# Gatwick Airport Northern Runway Project

Response to the Examining Authority's Written Questions  
(ExQ2) – Landscape, Townscape and Visual Resources

Application Document Ref: 10.56.10

PINS Reference Number: TR020005

Reproduced from Ordnance Survey map with the permission of Ordnance Survey on behalf of the controller of Her Majesty's Stationery Office © Crown Copyright (2023). License number 0100031673, 10001998, 100048492.

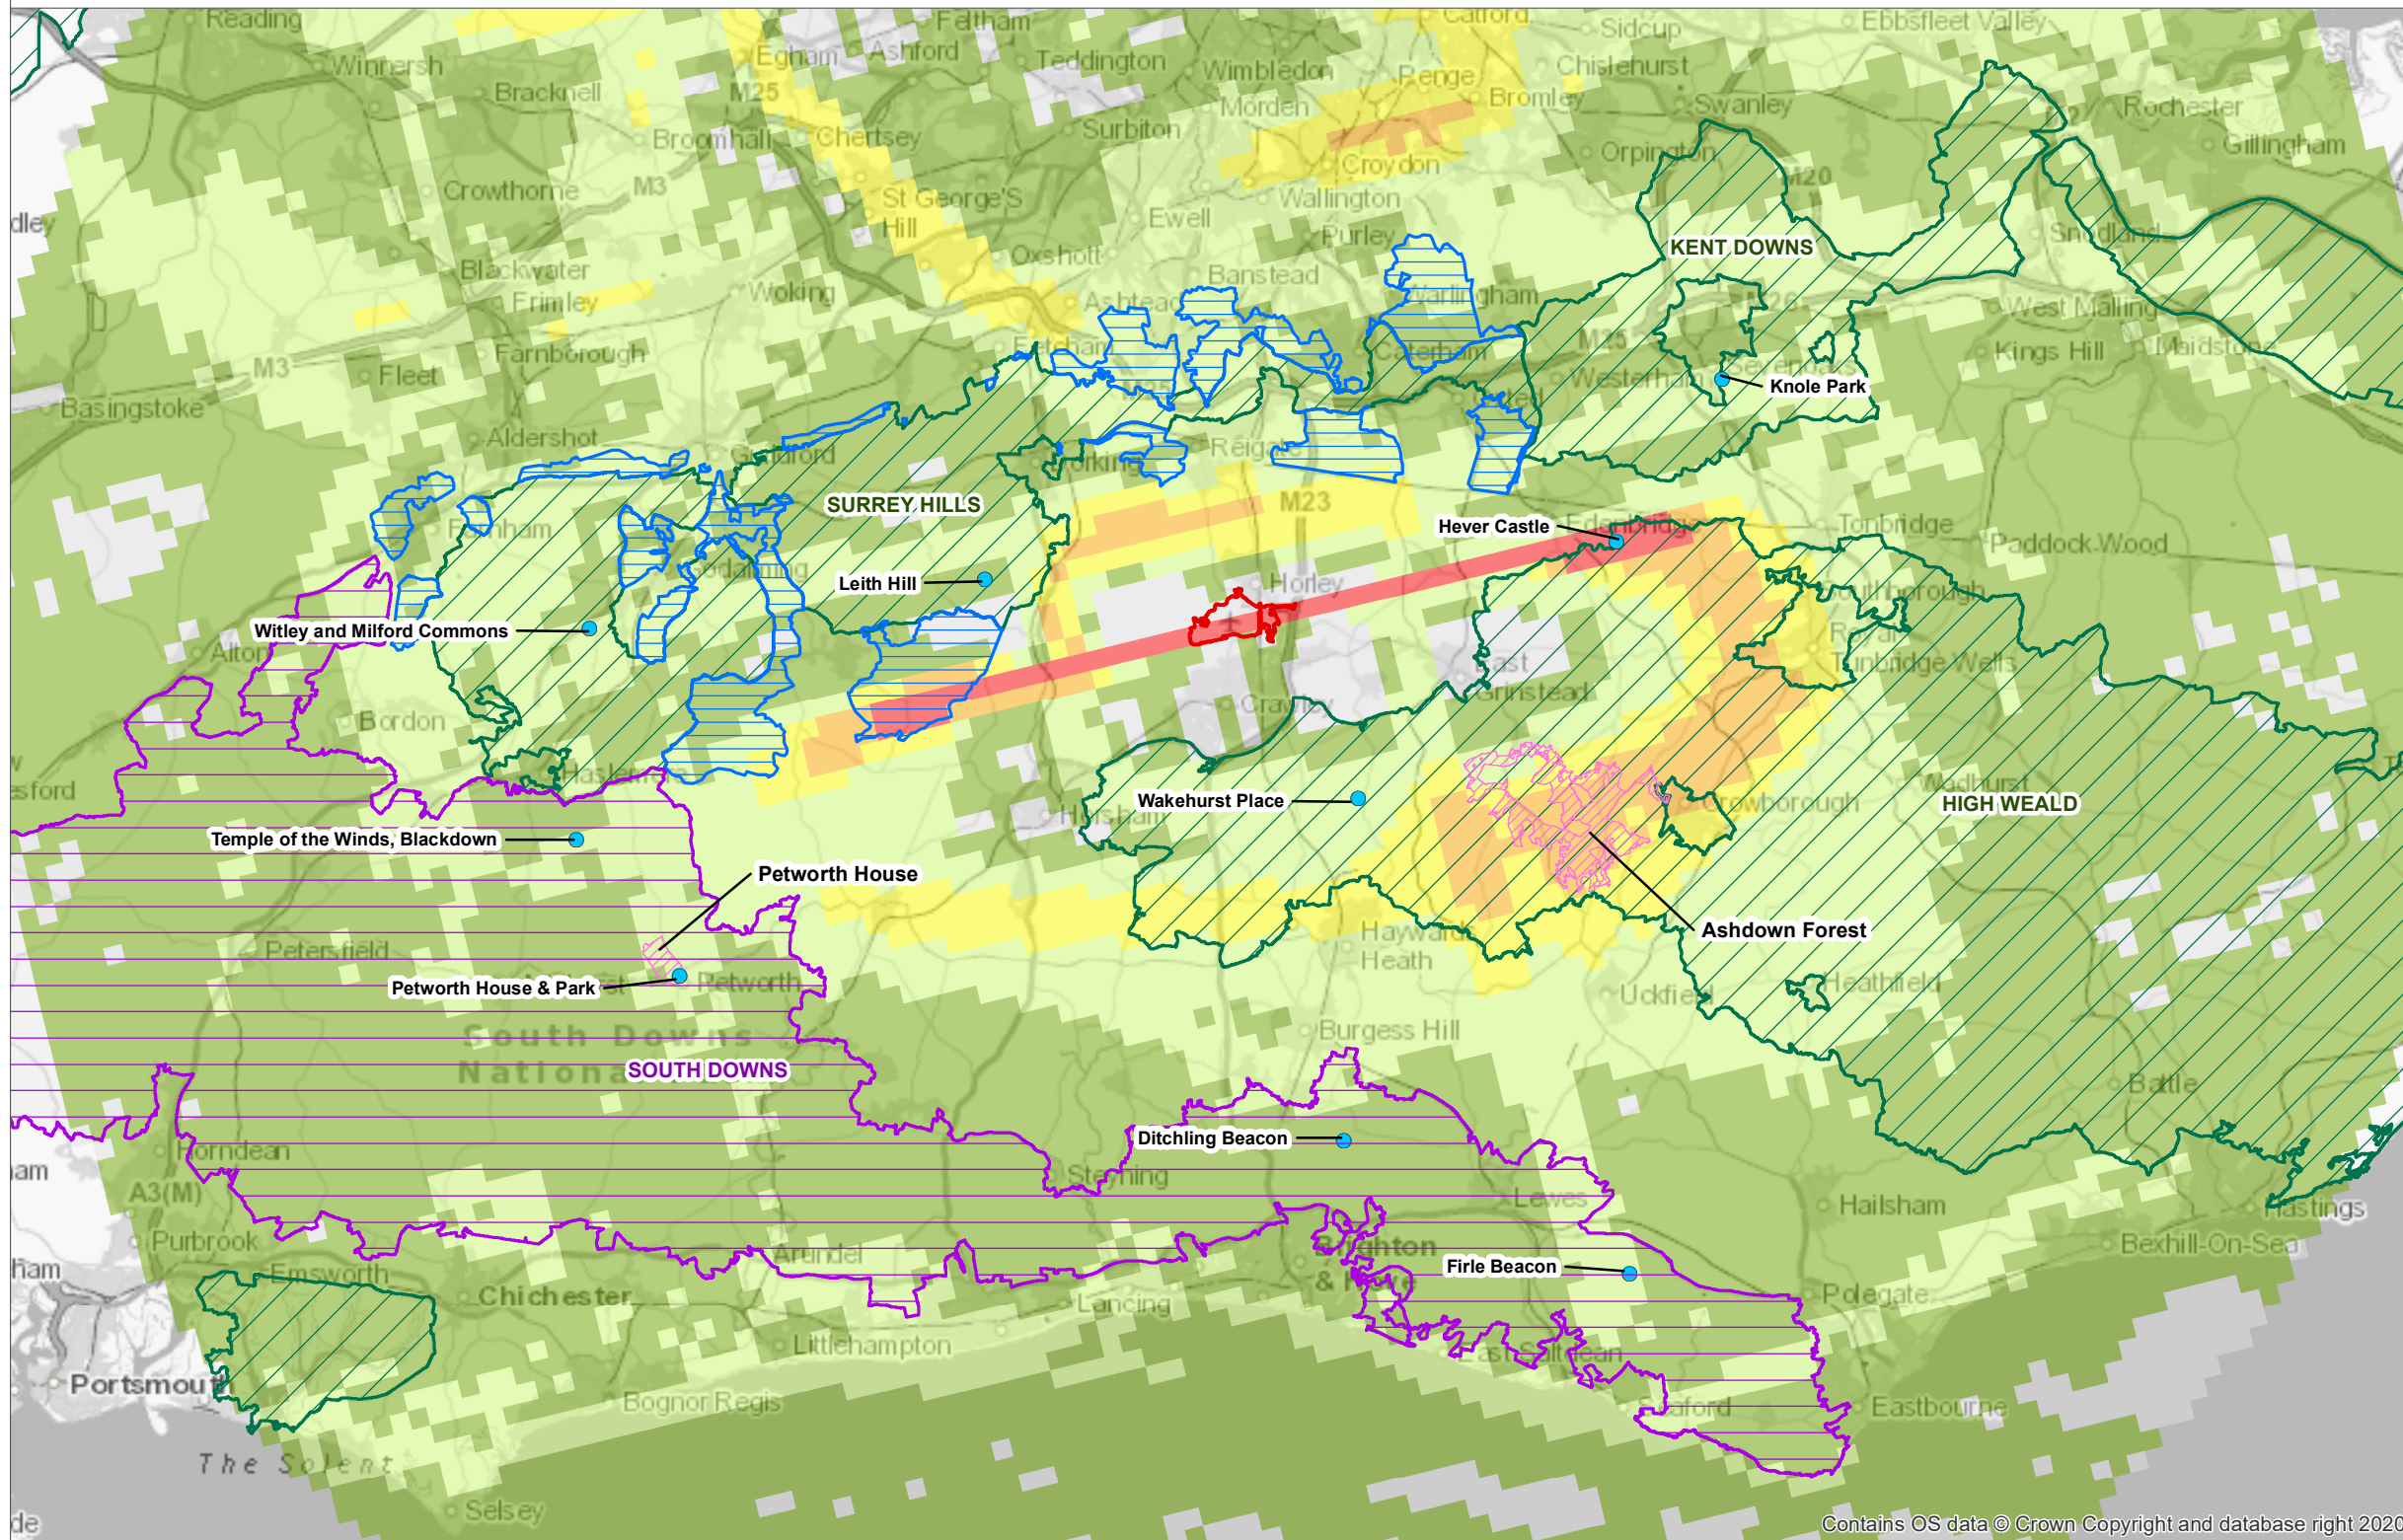
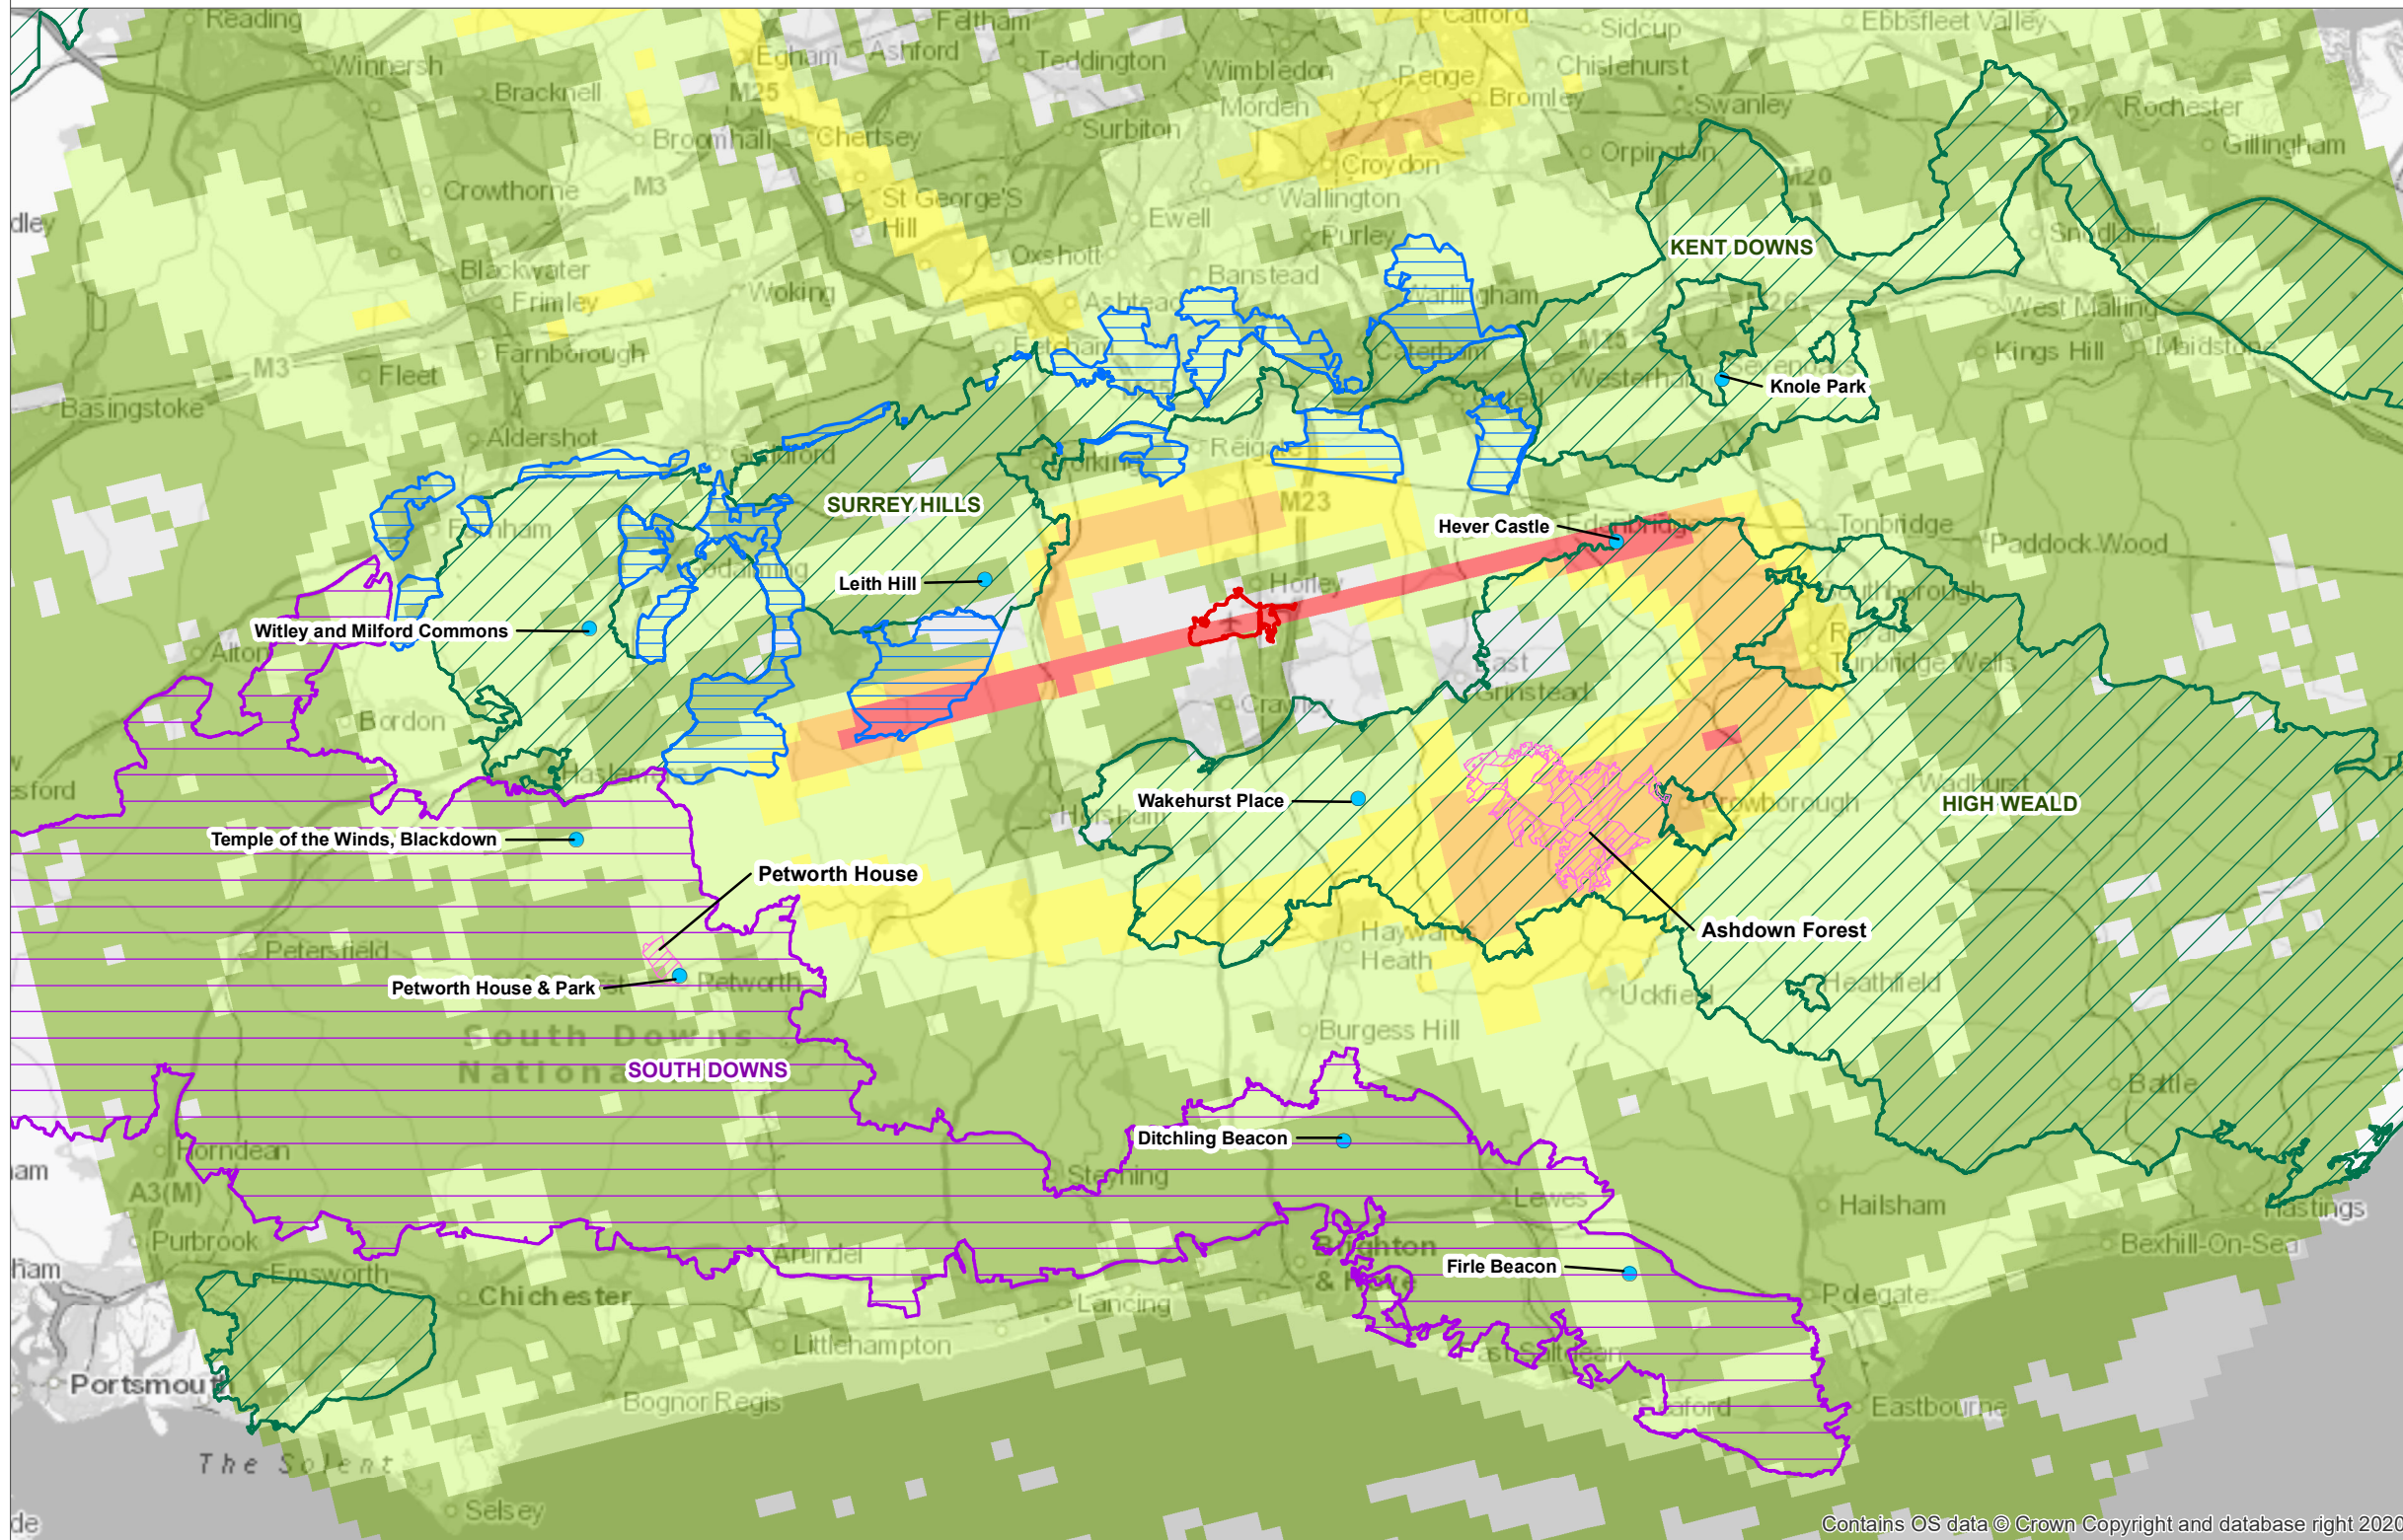
LV.2.2	Applicant	<p><b>Surrey Hills National Landscape</b></p> <p>While noting the answer to ExQ1 LV.1.8 and Appendix B to that answer, please provide further information concerning the likely extent of overflying (in terms of numbers and increase) which may occur over the proposed extended areas of the Surrey Hills National Landscape as a result of the Proposed Development.</p> <p>In addition to the survey and analysis work undertaken to inform the answer to ExQ1 LV.1.8 in <b>Applicant's Response to the ExA's Written Questions (ExQ1) - Landscape, Townscape and Visual Resources – Appendix A</b> [<a href="#">REP3-097</a>, <a href="#">REP3-099</a>] the Applicant updated the overflight heat maps ES Figures 8.6.3 to 8.6.7 in <b>ES Landscape, Townscape and Visual Resources Figures - Part 2</b> [<a href="#">REP2-007</a>] to identify the 15 Surrey Hills National Landscape Evaluation Areas for the proposed extension to the landscape designation, see Appendix A. The heat mapping for the proposed overflights, during both day and night time, is based on a forecast increase as a result of the Project by comparison to the future baseline situation of up to approximately 20% overflights by the end of 2032 and would not exceed this level of increase beyond 2033. No new flight paths are proposed as part of the Project. The increase in audible or visible overflights as a result of the Project is most likely to influence the perception of tranquillity within landscapes defined as Evaluation Areas 10, 11 and 12 to the north-east, north and west of Gatwick airport respectively. The areas of these landscapes which are currently overflown by the largest number of aircraft would experience the greatest number of additional aircraft, where relative tranquillity is slightly lower. No areas of landscape would experience an increase in overflights of more than 20%, therefore the assessment within the <b>ES Chapter 8: Landscape, Townscape and Visual Resources</b> [<a href="#">APP-033</a>] remains valid. The special qualities experienced by people including distant scenic views and relative tranquillity and dark skies would be affected to some extent however, they would still be positive qualities that would be experienced. An increase of up to approximately 20% in the number of aircraft following the same flight paths may be discernible to some residents or observers or barely perceptible to others. The magnitude of change would be negligible, leading</p>

to minor adverse effects on the perception of tranquillity during the day and at night, which is not considered to be significant.
LV.2.3	Applicant	<p><b>Visualisations</b></p> <p>The visualisations provided with the proposal show wireframe visualisations superimposed onto existing baseline viewpoint photography. Consider whether more detailed visualisations/ photomontages would be useful for certain sensitive viewpoints where visual effects would be most pronounced (including visualisations at certain times, for instance during construction, year zero, year fifteen) and provide them if appropriate or provide justification if not.</p> <p>The Applicant provided a <b>Note on Project Wide Habitat Loss and Replacement</b> <a href="#">[REP6-071]</a> at Deadline 6 to form a single point of reference with respect to a worst case habitat change that would result from the Project. The document includes illustrative material for eight key views within the surface access improvements corridor to illustrate vegetation loss and replacement and the creation of landscape proposals. The figures are based on panoramic site photography to show the existing situation with Photoshop visualisations to demonstrate landscape proposals at Year 1 and Year 10. The visualisations were prepared to the specifications set out by RBBC following a meeting on 14<sup>th</sup> May 2024. The locations of the visualisations are focussed within the surface access improvement corridor where some significant effects on landscape/townscape character and visual amenity have been identified within <b>ES Chapter 8: Landscape, Townscape and Visual Resources</b> <a href="#">[APP-033]</a>.</p> <p>The following documents provided by the Applicant are considered appropriate and sufficient to enable an understanding to be gained of the scale, mass and nature of development proposals and the character and concept of landscape and ecological proposals within the Project and how they interact with built form and infrastructure;</p>
